# **M3 Junction 9 Improvement**

**Scheme Number: TR010055**

## **5.1 Consultation Report Appendix E - EIA Scoping**

# **SCOPING OPINION:**

**DRAWING TITLE**  
 FIGURE 2.5 - THE SCHEME: TEMPORARY TRAFFIC DIVERSION ROUTES  
 APFP REGULATIONS 5(2)(a)  
 SHEET 1 OF 12  
 DOCUMENT REFERENCE 6.2

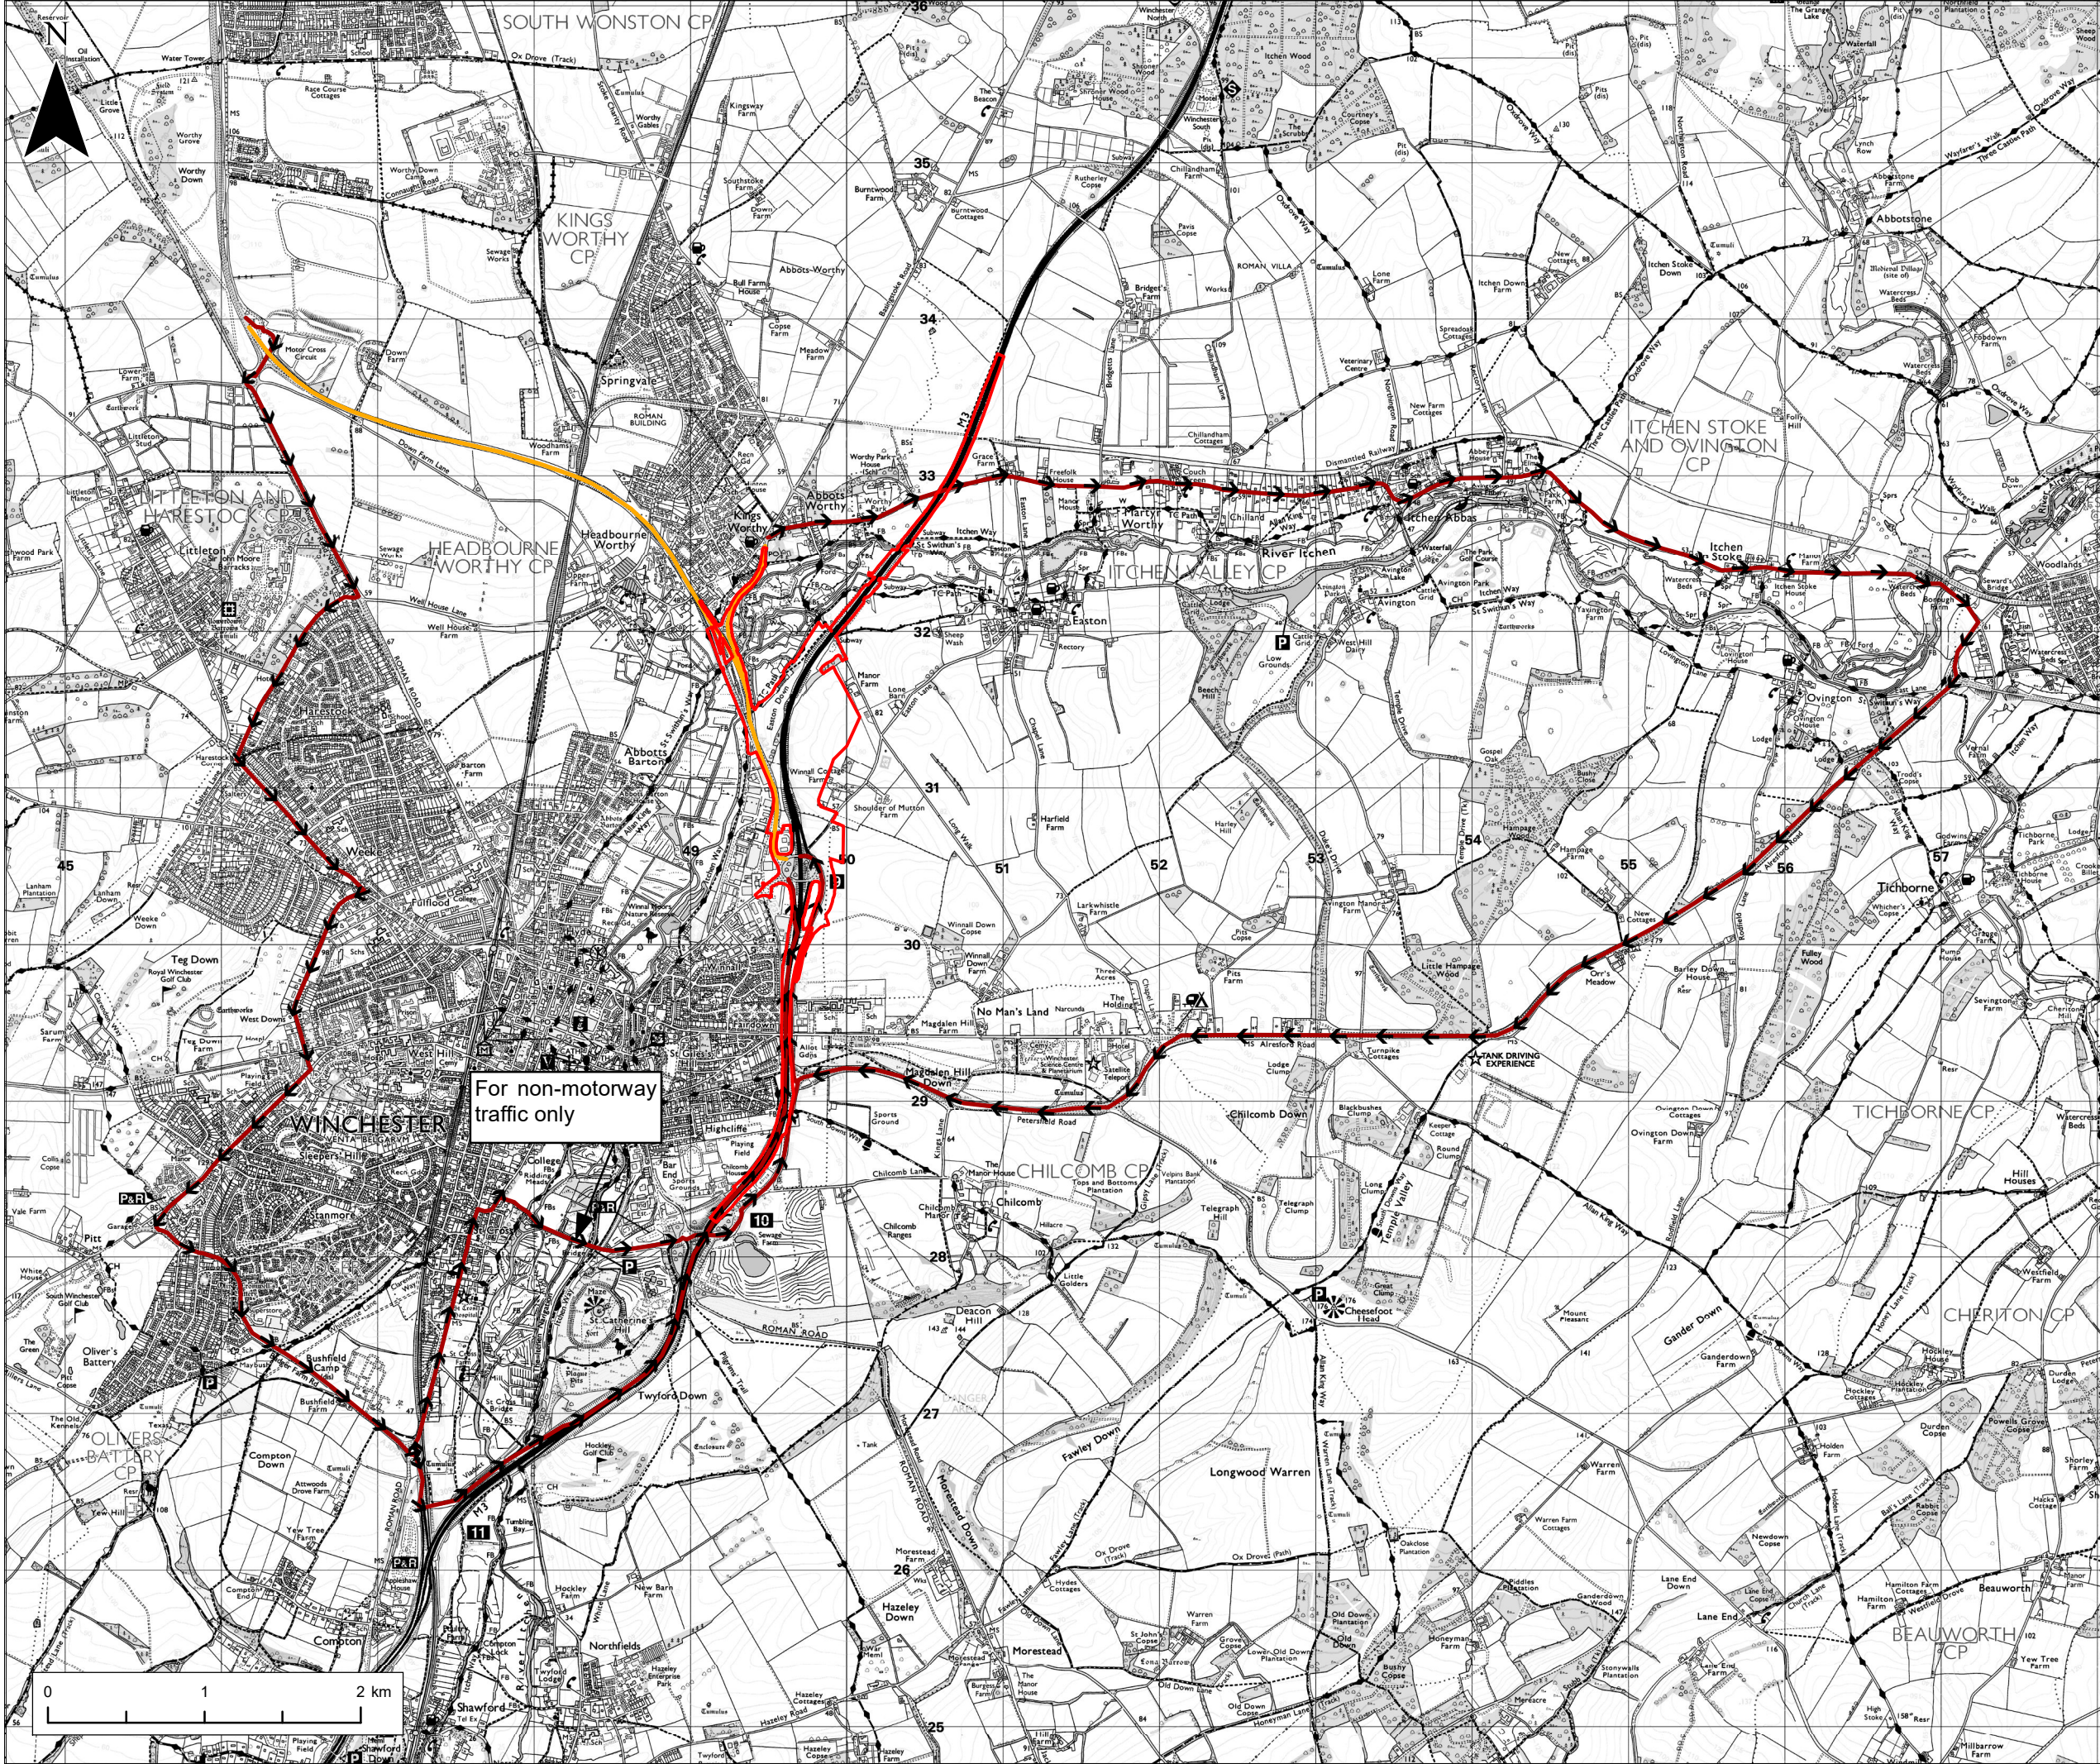
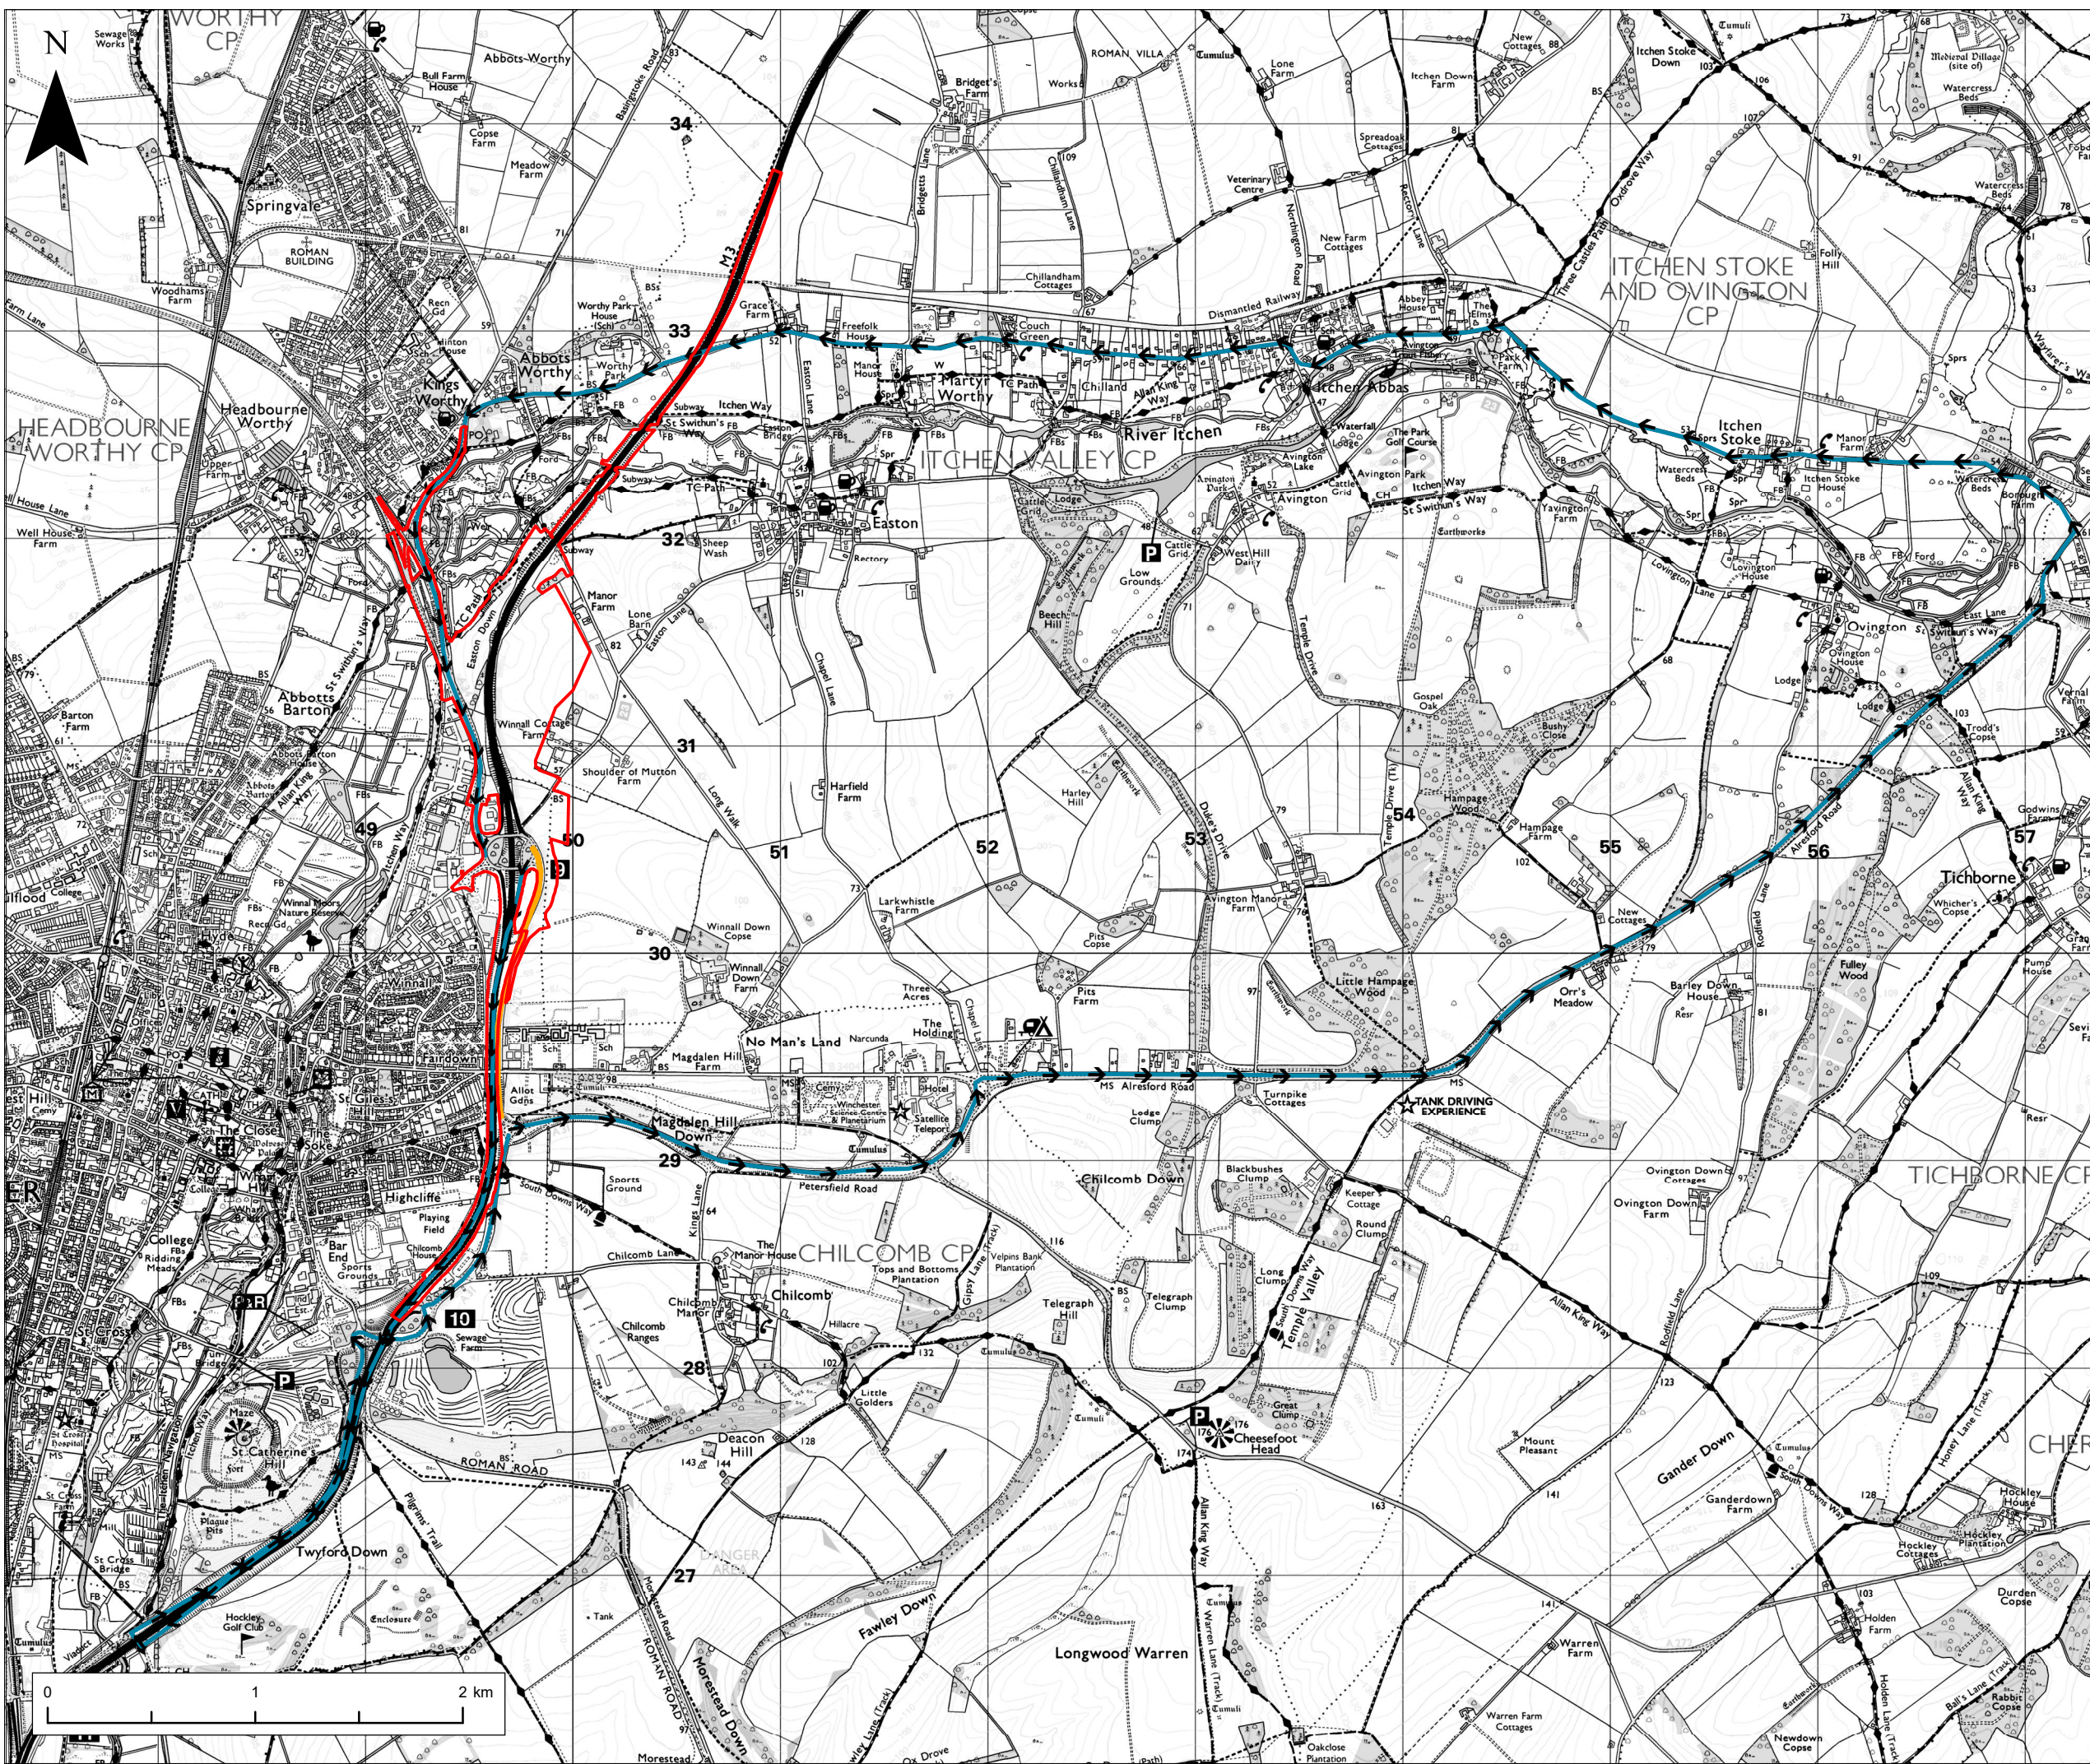
- 2.3.7 Diversions and closures of roads are listed to be required throughout in the construction phase. The ES should contain a full explanation of such closures and diversions, including whether they are temporary or permanent, and associated impacts should be fully assessed. This should also include any closures or diversions to Public Footpaths or Rights of Way.
- 2.3.8 This information should also be depicted on figures in the ES, to provide further clarity.
